From: Mau, Russell E (DOH) <Russell.Mau@DOH.WA.GOV>
Sent: Thursday, April 16, 2026 4:19 PM
To: Bradley Gasawski
Cc: Melissa Schumaier; 'elkhornanderson@gmail.com'
Subject: RE: SE-26-00001 Easton Travel Center - Notice of Application

Subject: Easton Travel Center SEPA Checklist (SE-26-00001) Public Comment

Fire Marshal comments
Easton Travel Center
SE-26-00001
Bradley Gasawski, Project Planner

RE: SEPA 202601588; SE-26-00001

SCALE GRAPHIC	EASTON TRAVEL CENTER	SHEET
DRAWN BY: LVE	PARCEL SITE PLAN	1
CHECKED BY: LVE	EASTON, WA	
SURVEYED BY:	DATE: FEBRUARY 13, 2024

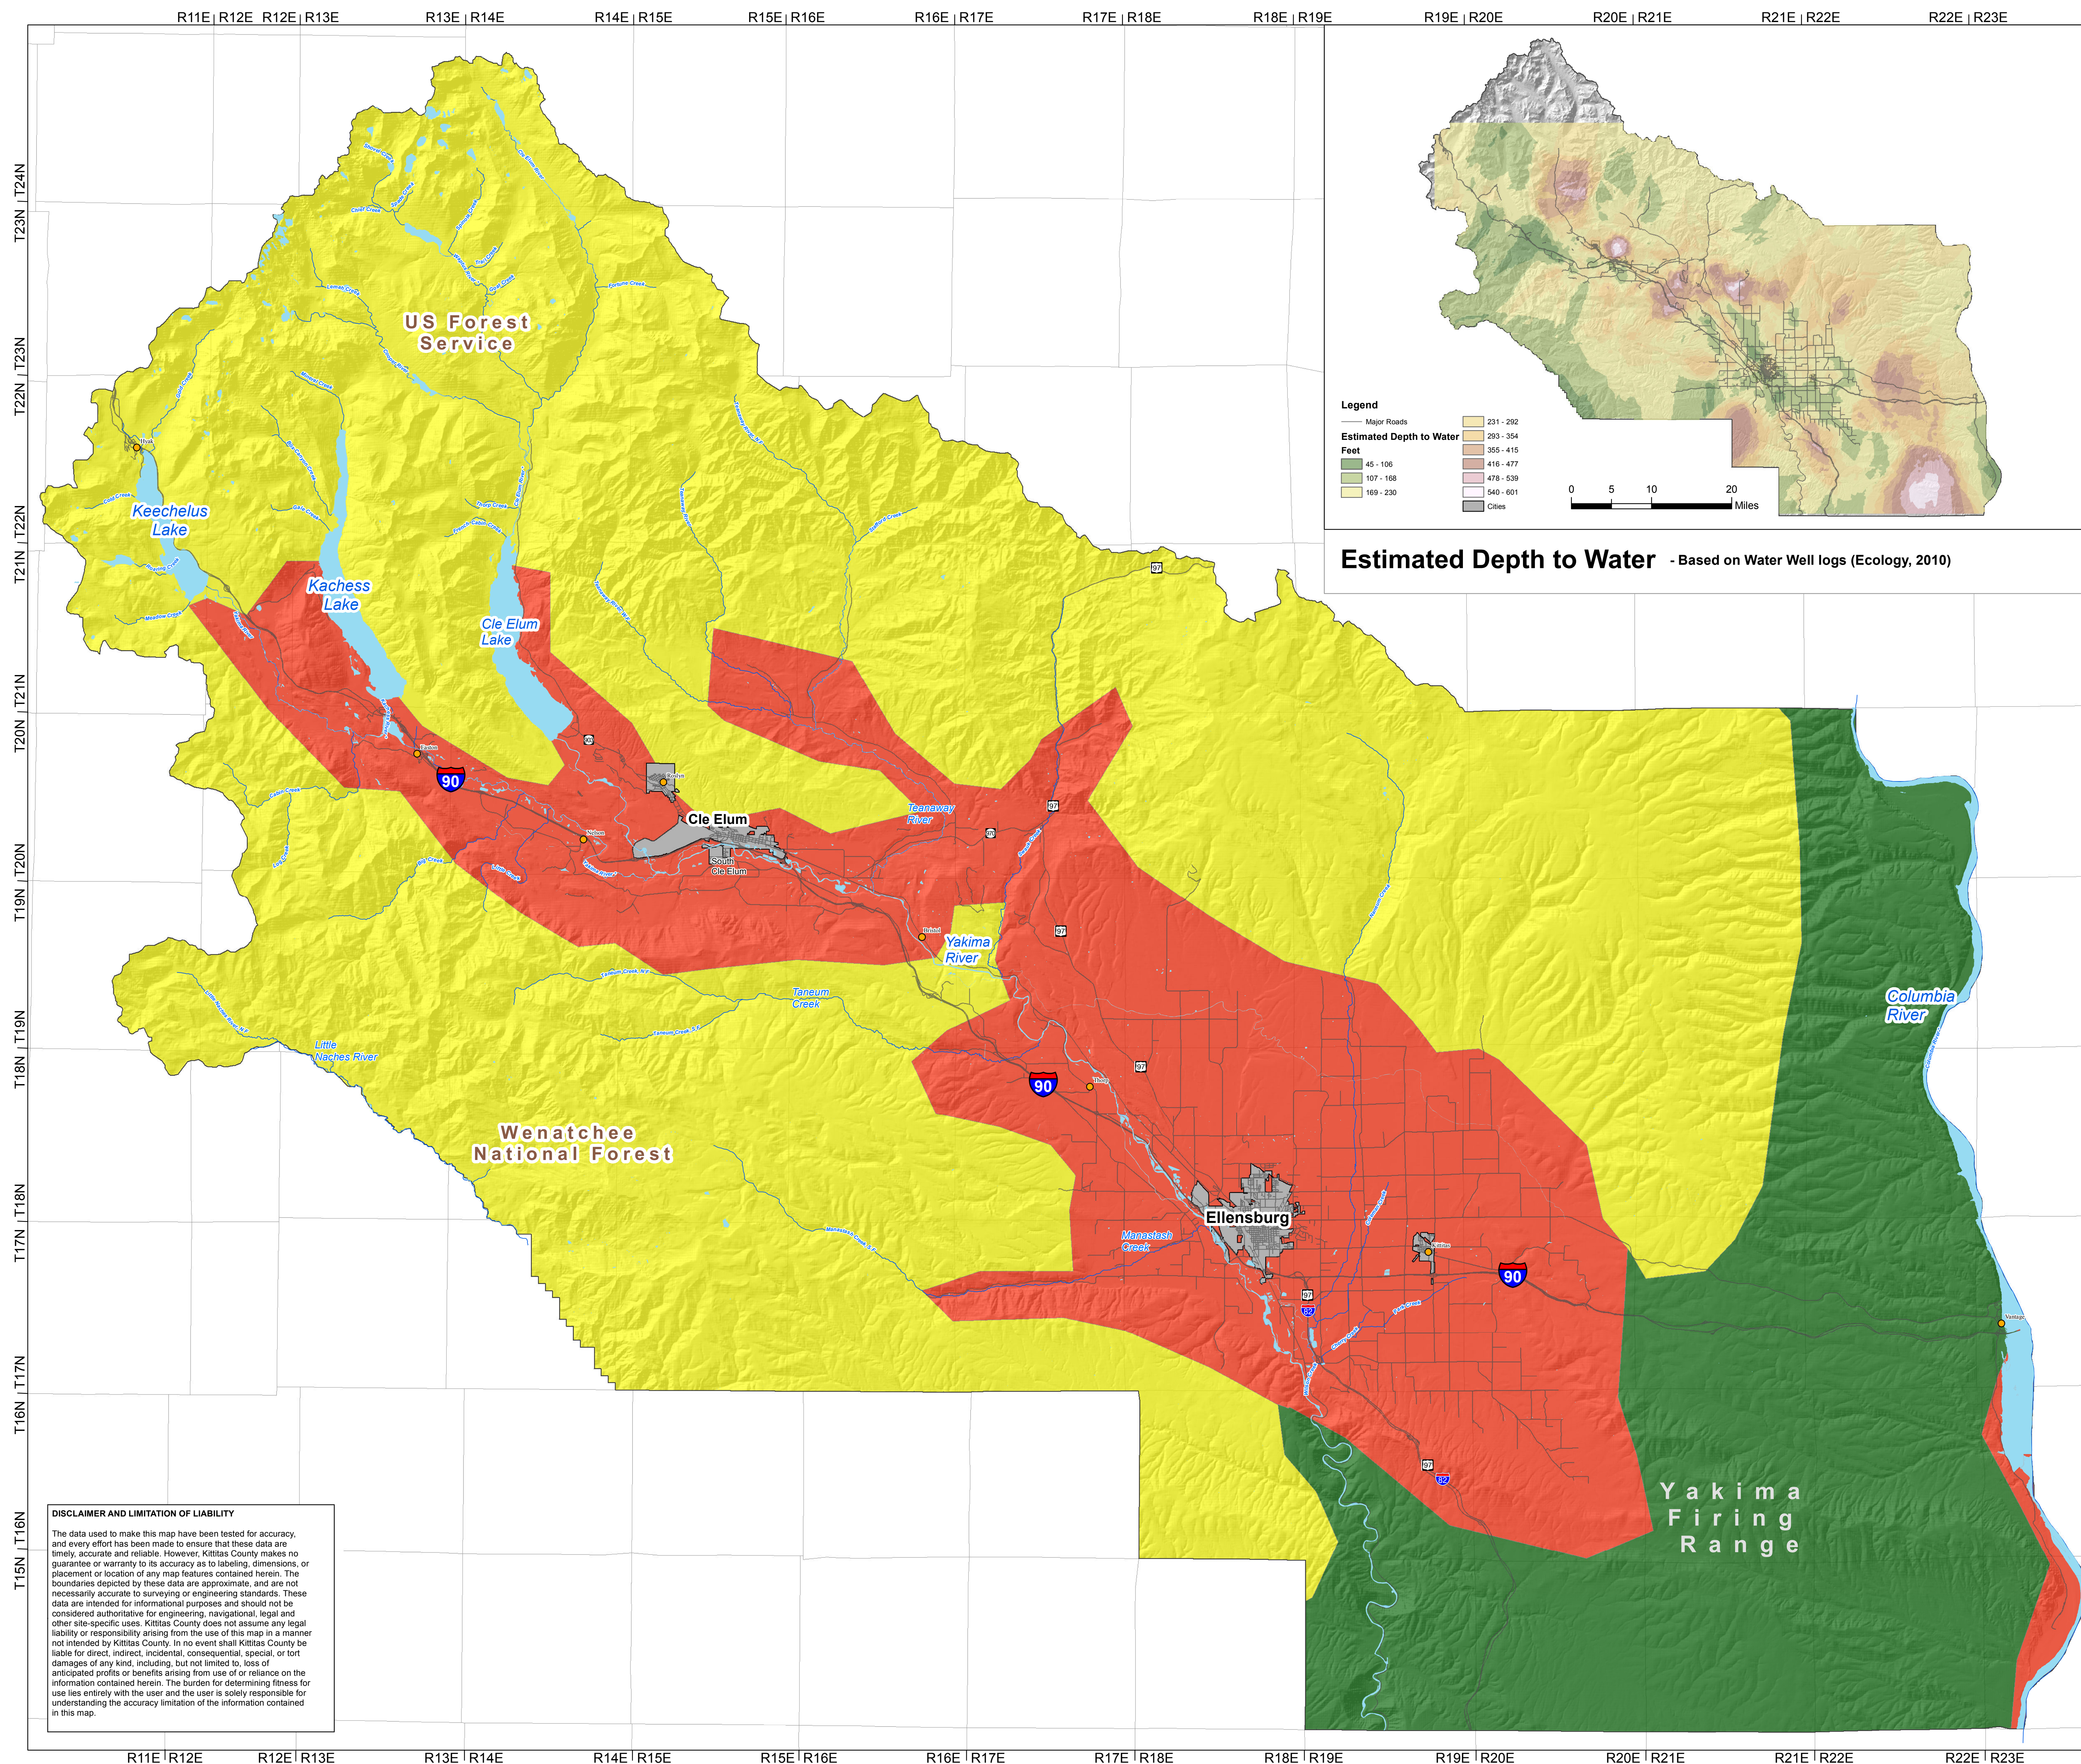
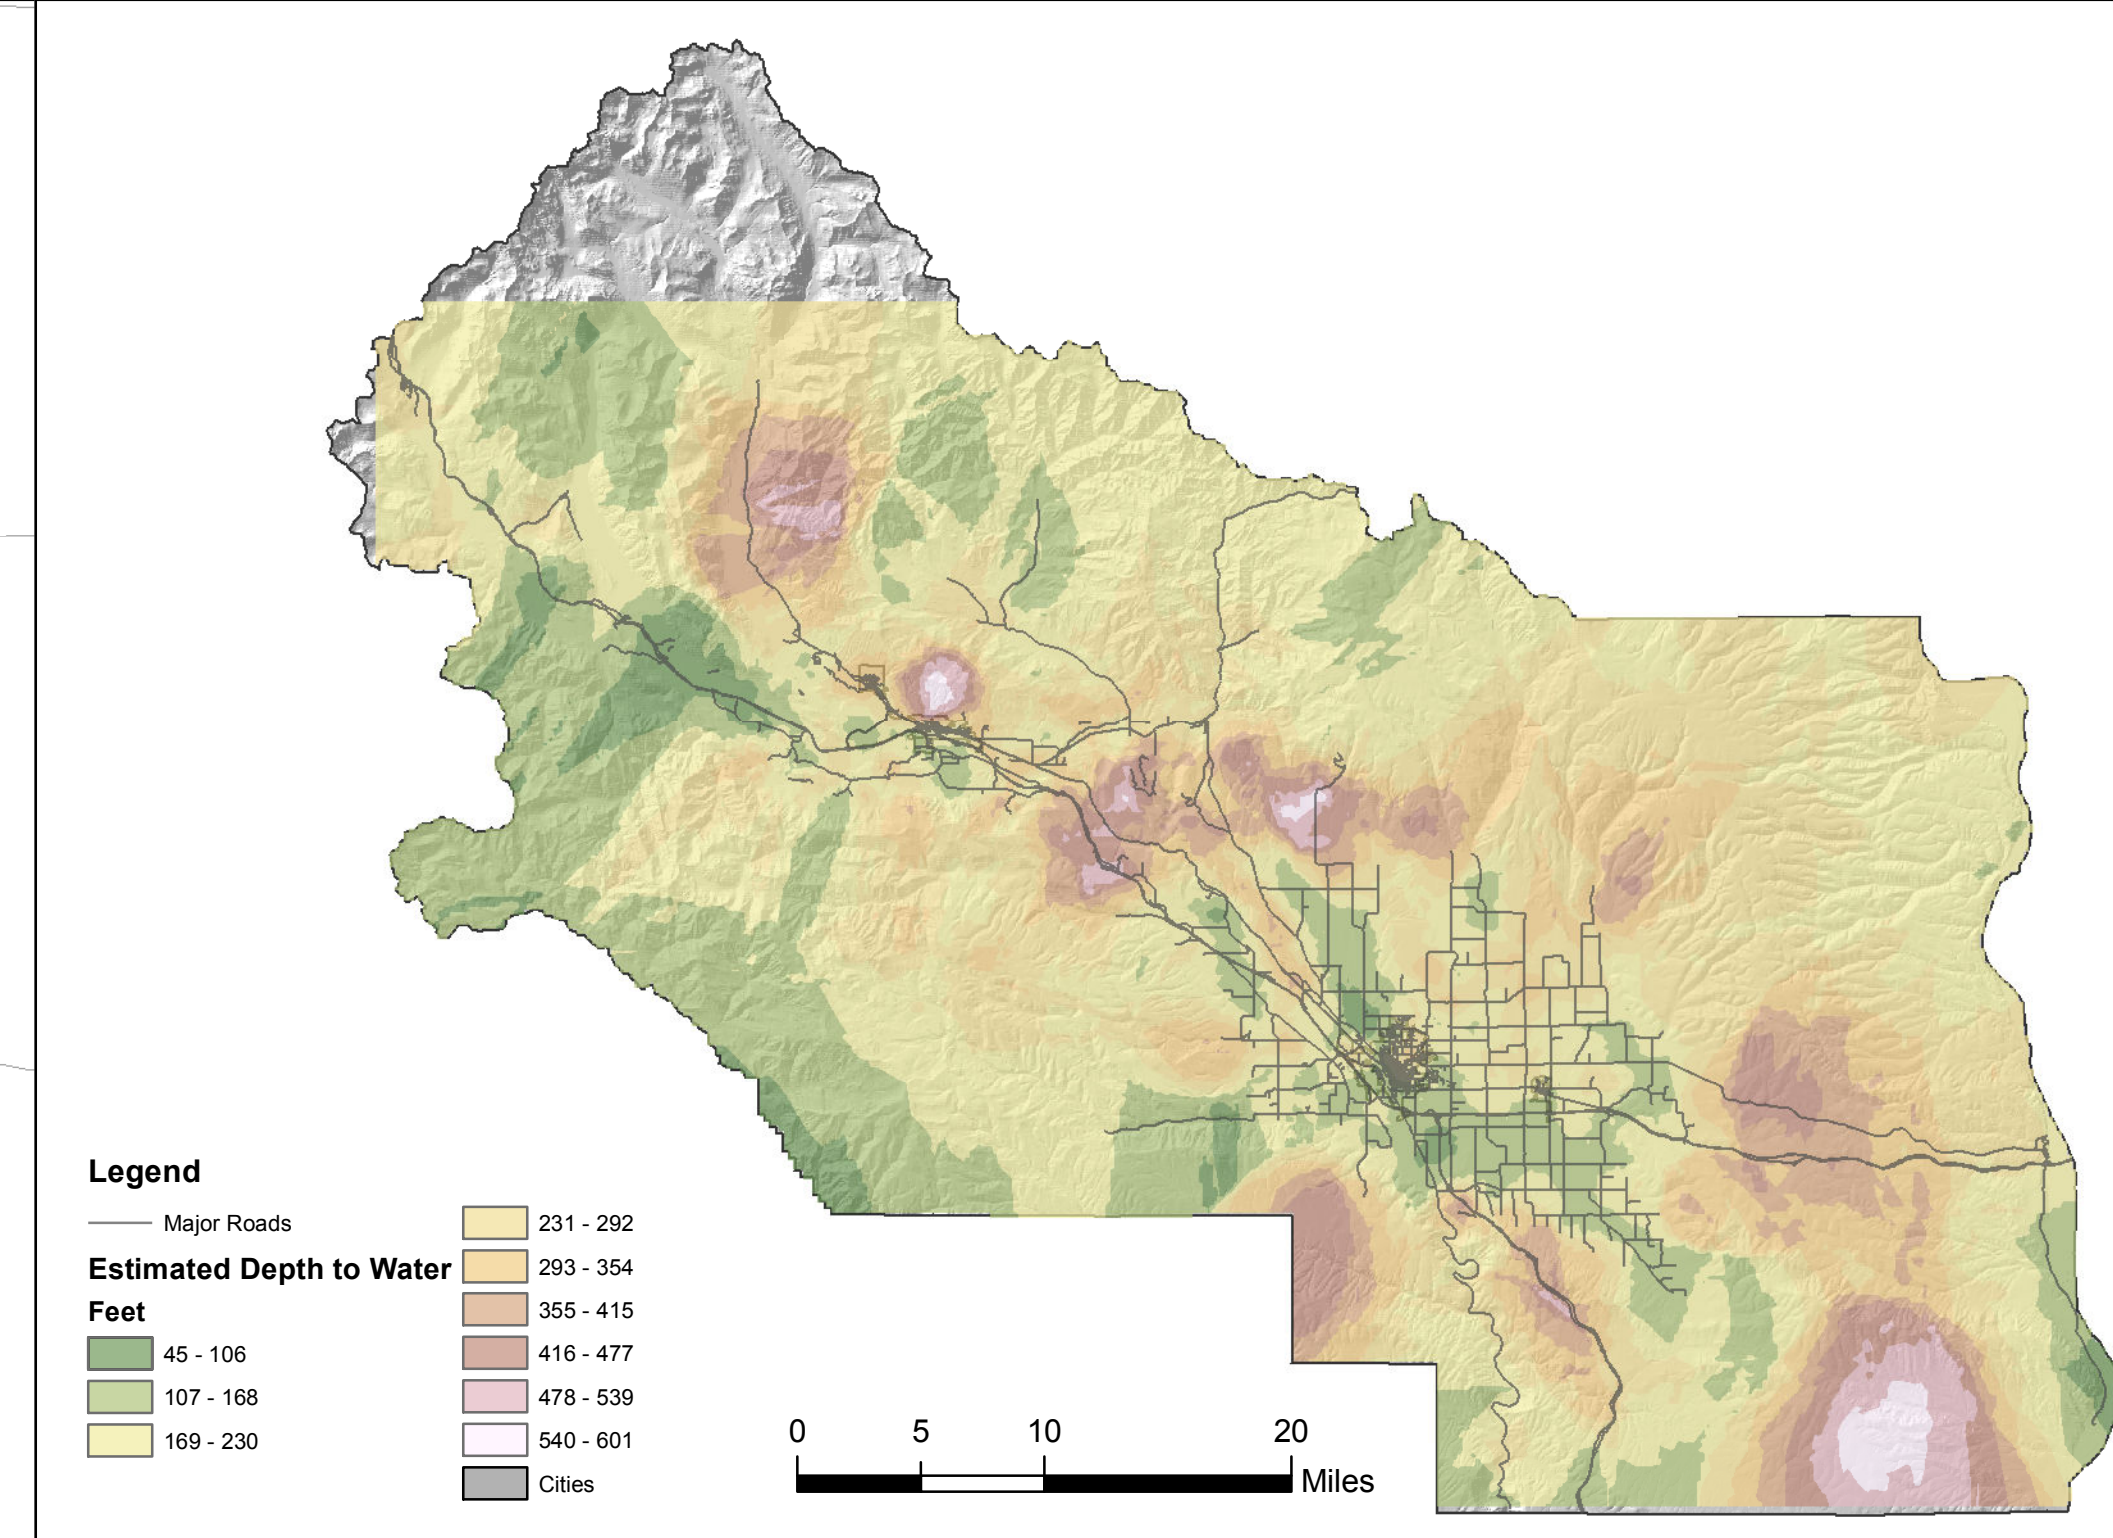
Fire flow in the amount of 2750 gallons per minute supplied for 120 minutes duration is required for this application. Prior to obtaining building permits, submit proof from the water purveyor indicating that the required fire flow is available at the site. Water mains supplying fire flow and fire hydrants shall be installed, approved and operational prior to the commencement of combustible building construction. Fire flow is based on a 10,000 square foot building of Type VB construction.

Fire hydrants are required for this application. Either the indicated number or the spacing of the fire hydrants is inadequate. Provide a minimum of 3 fire hydrants such that the average spacing between hydrants does not exceed 450 feet and such that no portion of the building exterior is in excess of 300 feet from a fire hydrant as measured along approved fire apparatus access roads.

The local fire district chief approves the exact locations of fire hydrants. As a condition of approval, contact Fire District # 3 to arrange for location approval. Unless waived by the fire district chief fire hydrants shall be provided with appropriate 'storz' adapters for the pumper connection. Provide and maintain a three-foot clear space around the entirety of every fire hydrant.

Fire apparatus access is required for this application. The roadways and maneuvering areas as indicated in the application adequately provide required fire apparatus access. Provide fire apparatus access roads with an unobstructed width of not less than 20 feet, an unobstructed vertical clearance of not less than 13.5 feet, with an all-weather driving surface and capable of supporting the imposed loads of fire apparatus. Access roads shall extend to within 150 feet of all portions of the facility and all portions of the exterior walls of the first story of the building.

Approved fire apparatus turnarounds are required for this project. The indicated provisions for turning around fire apparatus are adequate.
